COMMUNITY SERVICES DEPARTMENT

Subject: FAWA/Bar-X Water Transmission Line 1041 Permit Application Review (AASI-22-004)

The Park Operations Division of the Community Services Department has reviewed the 1041 Permit Application for the Falcon Area Water Authority (FAWA) Bar-X Water Transmission Line and has the following administrative comments of behalf of El Paso County Parks.

FALCON WATER AUTHORITY
 272.02 BAR X 1041
APPENDIX R - ROW AND EASEMENT MAP

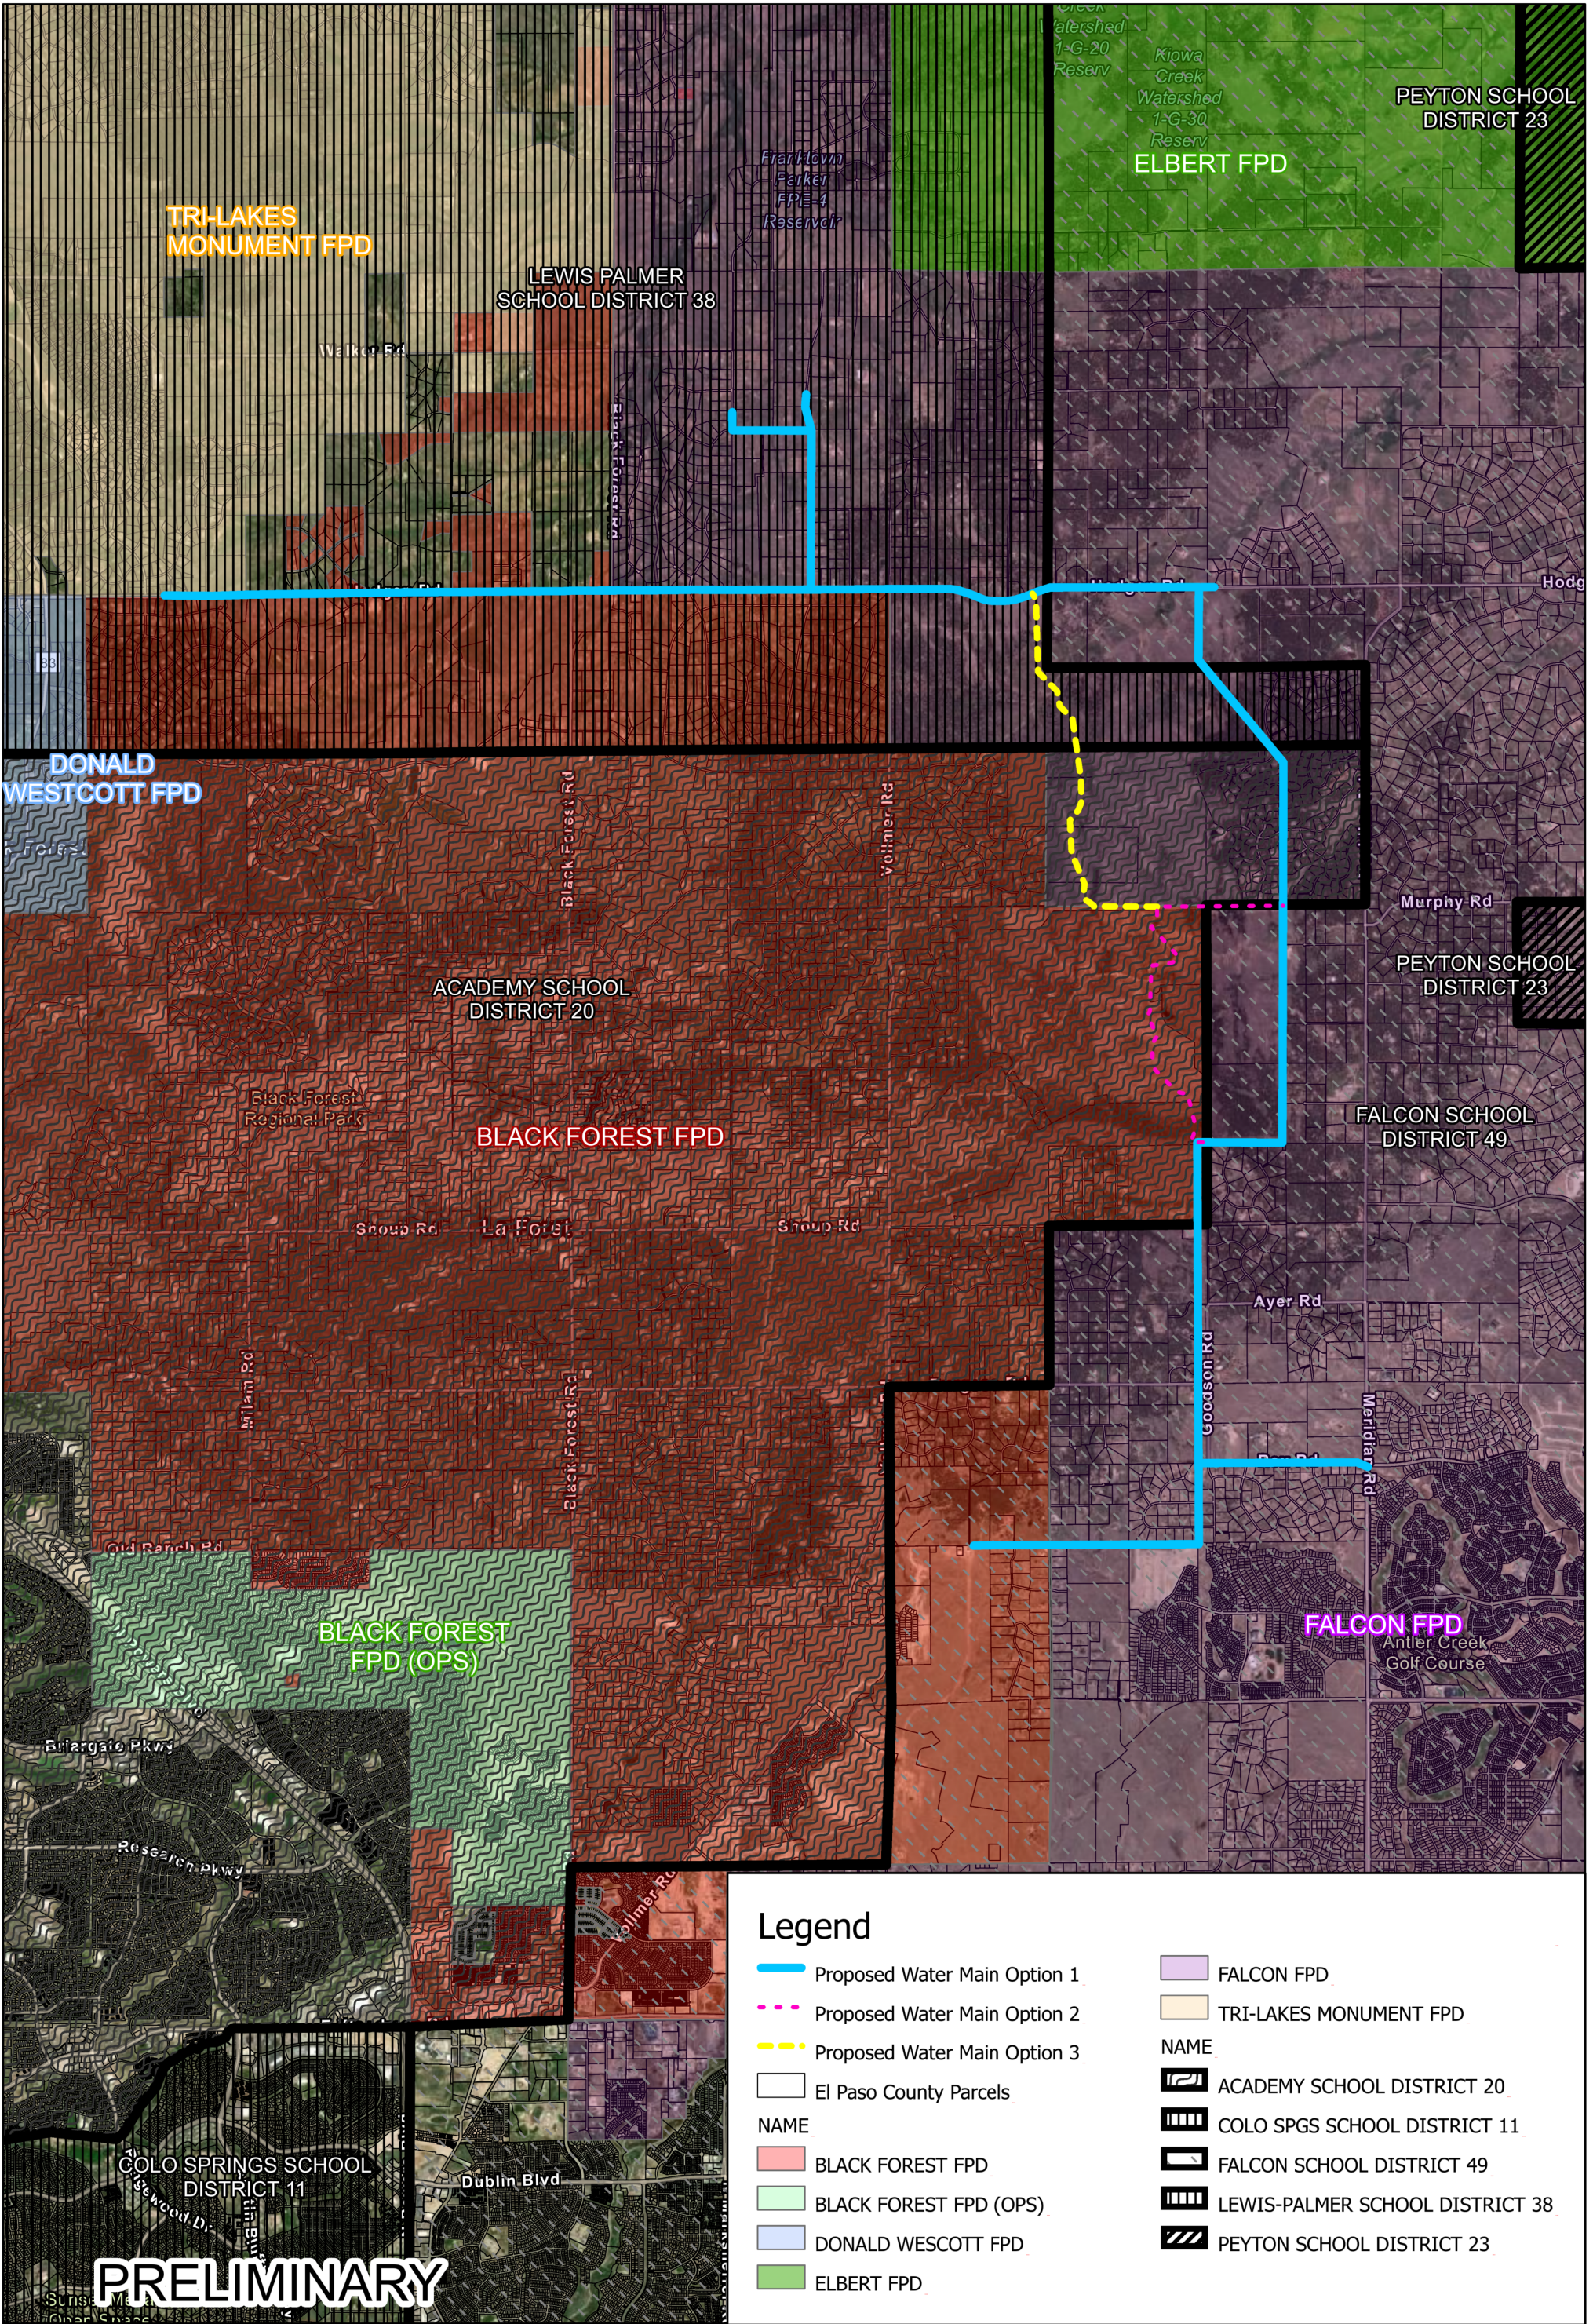
- The pipeline may be installed along the eastern and southern boundaries of the Excel powerline easement, within 50 feet of the eastern and southern property boundaries of Pinerias Open Space. The western and northern boundaries of this easement are located immediately adjacent to sensitive areas within Pinerias Open Space and include old-growth forest, sensitive wetland environments, and those areas that are recovering from the Black Forest Fire of 2013 (see attached map).

- If the water tank located on property owned by San Miguel Valley Corporation is to be utilized, the incoming/outgoing pipeline(s) shall be located on properties located immediately to the north of Pinerias Open Space, only crossing the 150'-wide County-owned open space property adjacent and north of the water tank. An east-west pipeline along the northern Pinerias property line would create too great of an impact on the vehicle access road and adjacent forest and singletrack trail system. The pipeline(s) would travel east-west to the Option 1 pipeline using SMVC property and the local powerline easement located immediately north of the Pinerias Open Space boundary. The incoming/outgoing pipeline(s) would cross EPC property on the crest of the Palmer Divide to reduce impacts on the surrounding terrain and existing trail (see attached map). This portion of the project will be restored following the guidelines below.
